29-L-1

207-209 Fore St.

Revised Traffic Analysis Memo

Subject: **Response to Traffic Comments**
Old Port Hospitality, LLC – Phase 2
Fore Street, Portland

**2010 AM & PM BACKGROUND TRAFFIC VOLUMES**  
**MIDDLE STREET AT INDIA STREET**

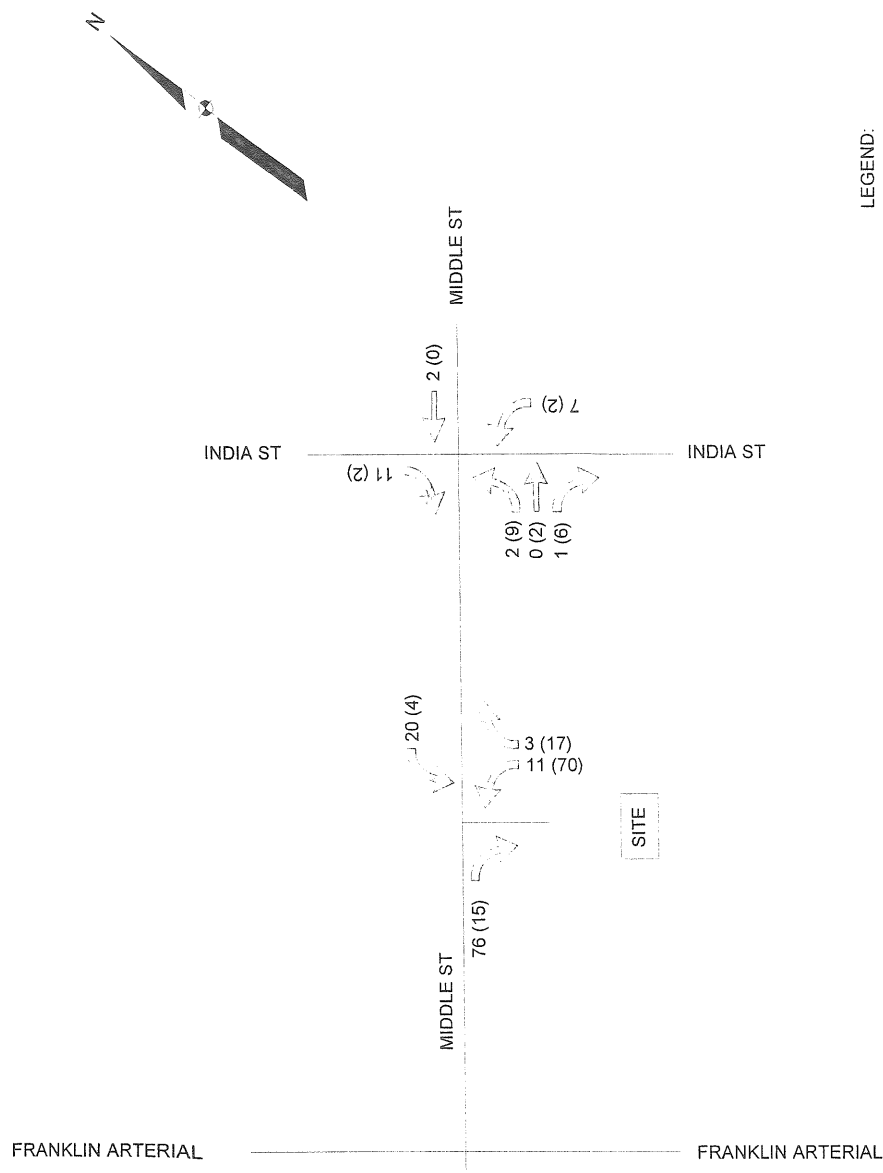
2. Looking at the turning movement volumes, I was surprised at the distribution. Examples include the low volume turning right onto Middle Street from southbound India Street in the morning and the reverse movement in the evening. Please check the data. Also, please note whether there were any substantial traffic detours in the area during the time of the count.

Response: We have reviewed our traffic counts from July 21st and made some adjustments. These are shown in Figure 1. We have also attached a copy of the Temporary Traffic Control Plan that was in effect on the date of our traffic counts. It appears from the plan that more vehicle traffic may have been using the intersection of Middle Street at India Street due to Fore Street being closed to thru traffic and only open for local traffic. With this condition in effect we still felt the traffic counts would be valid and may provide a more conservative analysis.

SCALE: NTS  
 DATE: 07/22/2010  
 SHEET: Fig. 3

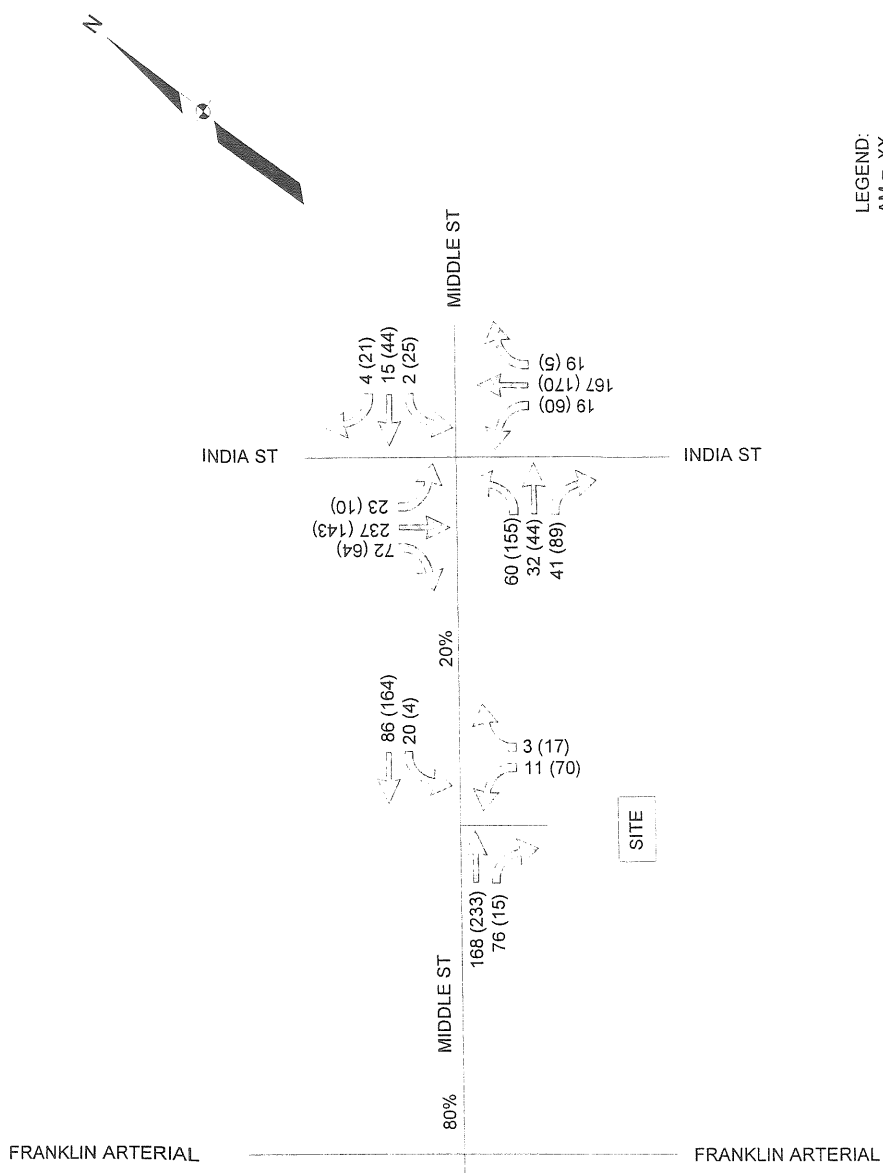
1. Knowing that several other developments in the area have been permitted it is unclear whether the build traffic volumes include approved projects (Village Café site, Ocean Gateway, Phase Hotel, etc.). These projects should be included.

Response: We have included other development trips for the Riverwalk and Bayview projects. The other development trips are shown in Figure 3 enclosed at the end of this report.
